AQUIND INTERCONNECTOR

Statement of Common Ground Between
AQUIND Limited and the South Downs
National Park Authority
Agreed Draft

DOCUMENT: 7.5.7

DATE: 25 JANUARY 2021

Figure 15.49: Indicative Landscape Mitigation Plan Option B(1) (south)

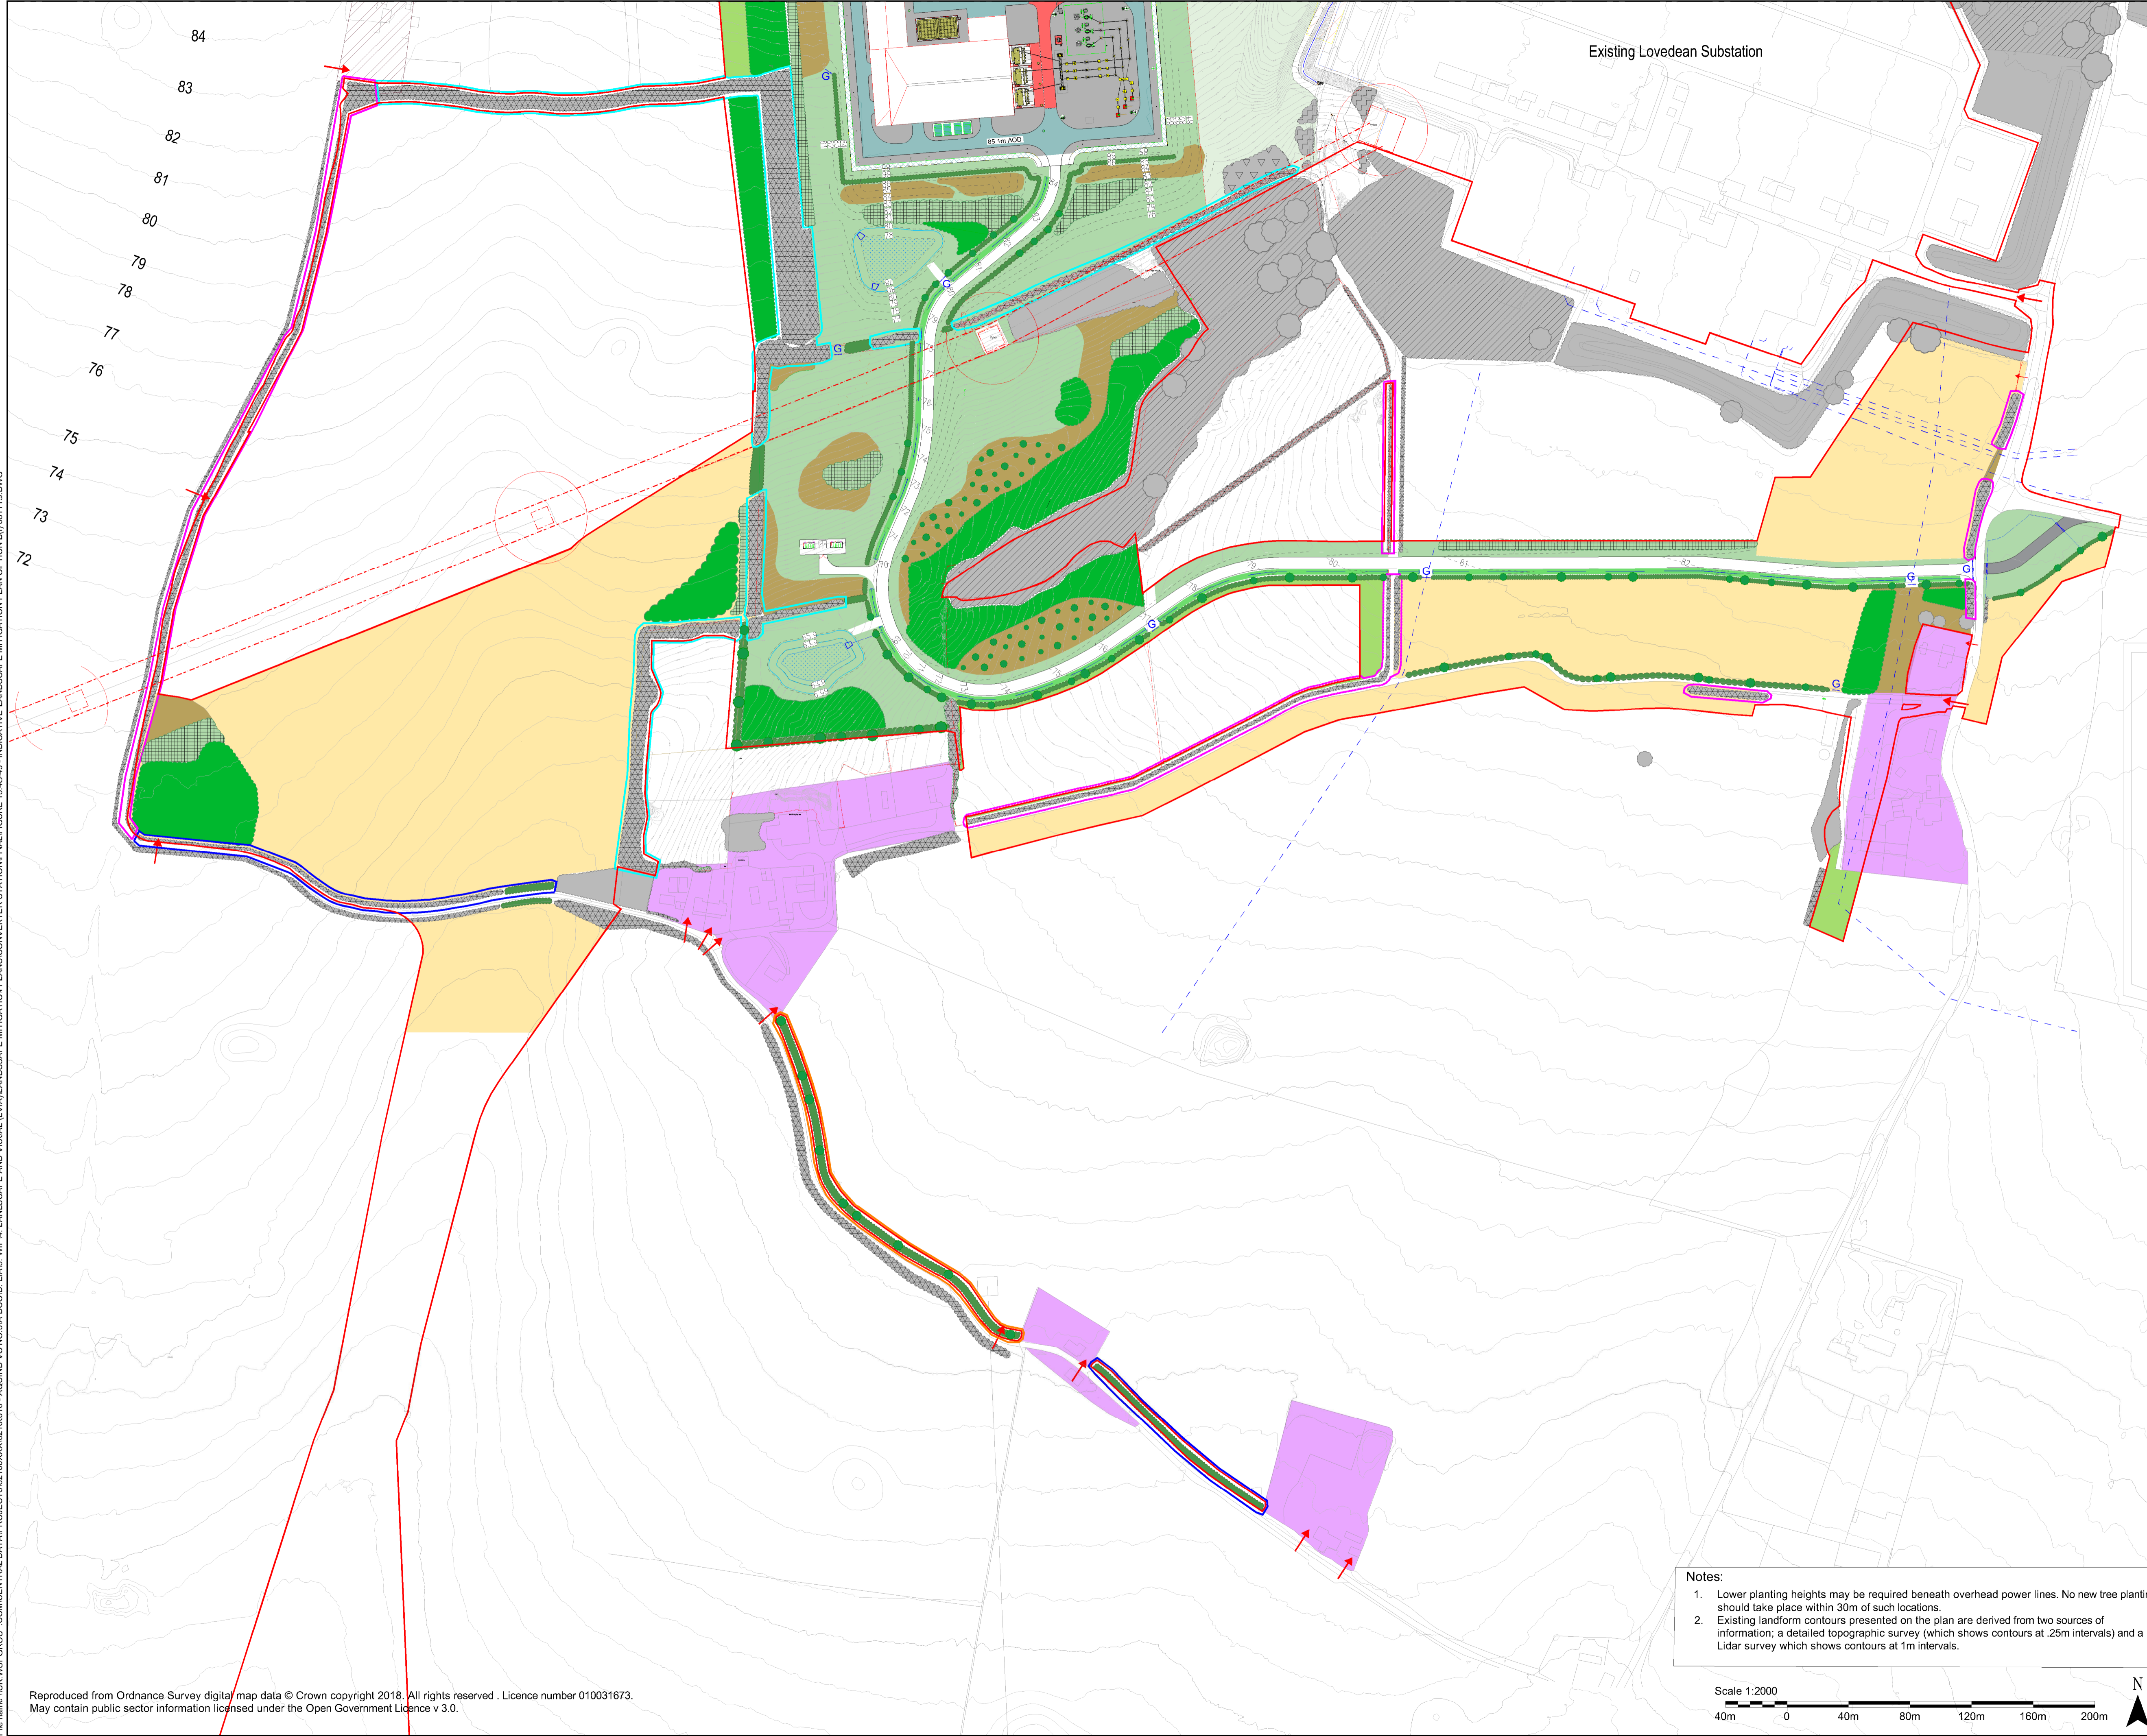
SDNPA 4.3.10	Residual effects – Section 1 General	The Applicant seeks the SDNPA’s review and agreement of the assessment of residual effects relating to Section 1 set out at Tables 15.10 and 15.11 of Chapter 15 of the ES or otherwise seeks confirmation from the SDNPA what aspects are not agreed.	Ongoing
SDNPA 4.3.11	Residual effects – Access Road	<p>The Applicant seeks agreement that the predicted impact associated with the proposed Access Road is that it dissects fields and will result in moderate adverse effects in year 0, and by year 10 minor adverse non-significant effects, as identified within the ES.</p> <p>The SDNPA has raised concerns over the following:</p> <ul style="list-style-type: none"> • The change in character along Broadway Lane and Day Lane; • Direct long views along the new Access Road; • The nature of fencing; • Greater consideration of a more sensitive design. <p>The SDNPA has noted that the proposed Access Road is right on the National Park’s boundary, and that the change to that corner of the field will be significant. The SDNPA has queried whether it will result in the loss of an existing hedgerow, and the Applicant has confirmed that an existing</p>	Ongoing

Ref.	Description of matter	Current Position	RAG
		<p>hedgerow will be lost, hence the assessment concluded a significant effect in this location. Proposals to soften this area (which include a new area of woodland and the relocation of a proposed hedgerow closer to the “gated link road” have been explored by the Applicant and are presented on revised versions of the indicative landscape mitigation plans for both Option B(i) north and south (REP6-027 and REP6-028) and landscape mitigation plans for Option B(ii) (REP6-054) and reflected in an updated version of the OLBS (REP6-038).</p> <p>The Applicant seeks confirmation that the SDNPA agrees, based on the above, the impacts associated with the Access Road will be moderate adverse effects in year 0, and by year 10 minor adverse non-significant effects, as identified within the ES. The SDNPA is considering the new information submitted by the Applicant and will be commenting in due course in accordance with the examination timetable.</p>
